Subject: Rezoning Petition Review

Rezoning Petition #: 21-201

Location of Property: Approximately 1.15 acres located in the northwest quadrant of the intersection of Weddington Ave and Bascom St, east of E 7th St.

SHEET NAME
REZONING SITE PLAN

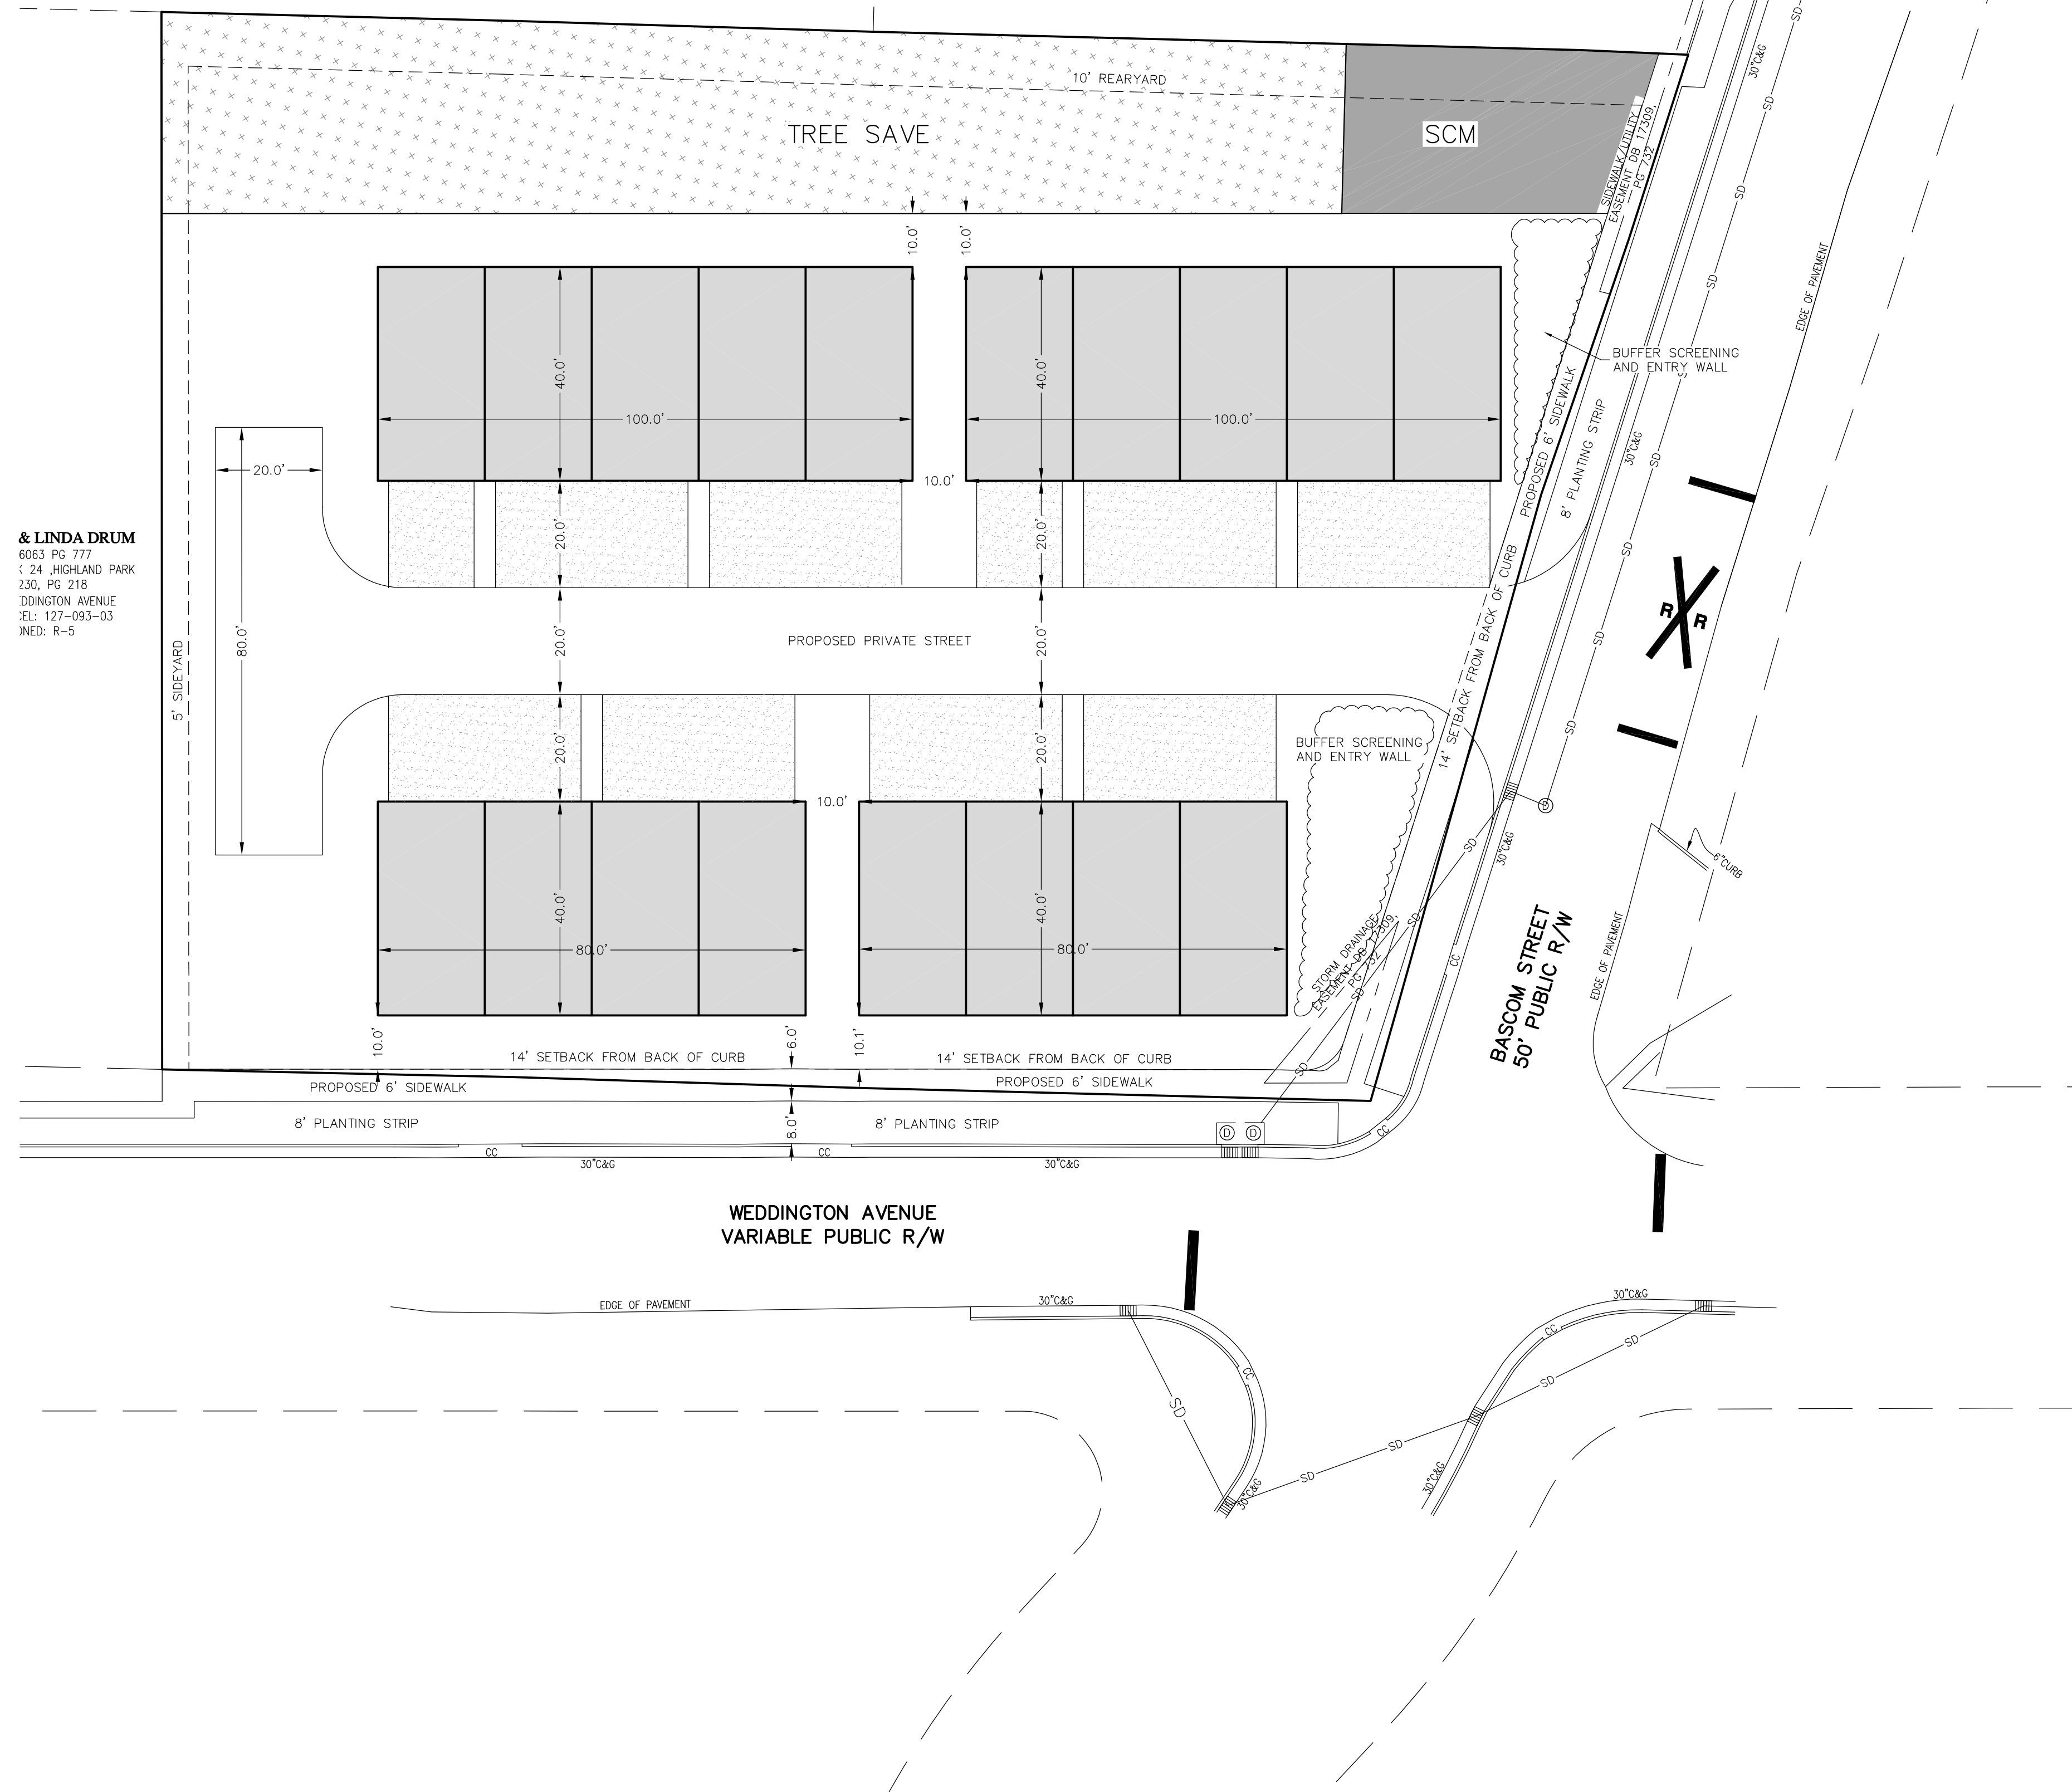
The proposed rezoning plan sheet indicates a proposed location for storm water management. Please include the following notes on the plan sheet under "Environmental Features": *The location, size, and type of storm water management systems depicted on the Rezoning Plan are subject to review and approval as part of the full development plan submittal and are not implicitly approved with this rezoning. Adjustments may be necessary in order to accommodate actual storm water treatment requirements and natural site discharge points.*

This property drains to Briar Creek, which is an impaired/degraded stream, and may contribute to downstream flooding. This project has the opportunity to mitigate future impacts to this stream, therefore, Storm Water recommends placing the following notes on the plan:

For defined watersheds greater than 24% built-upon area (BUA), construct water quality stormwater control measures (SCMs) designed for the runoff generated from the first 1-inch of rainfall for all new and redeveloped BUA associated with the project. SCMs must be designed and constructed in accordance with the Charlotte-Mecklenburg BMP Design Manual.

For defined watersheds greater than 24% built-upon area, control the entire volume for the 1-year, 24-hour storm for all new and redeveloped BUA associated with the project. Runoff volume drawdown time shall be in accordance with the Charlotte-Mecklenburg BMP Design Manual.

For residential projects with greater than 24% BUA, control the peak to not exceed the predevelopment runoff rates for the 10-year and 25-year, 6-hour storms or perform a downstream analysis to determine whether peak control is needed, and if so, for what level of storm frequency.
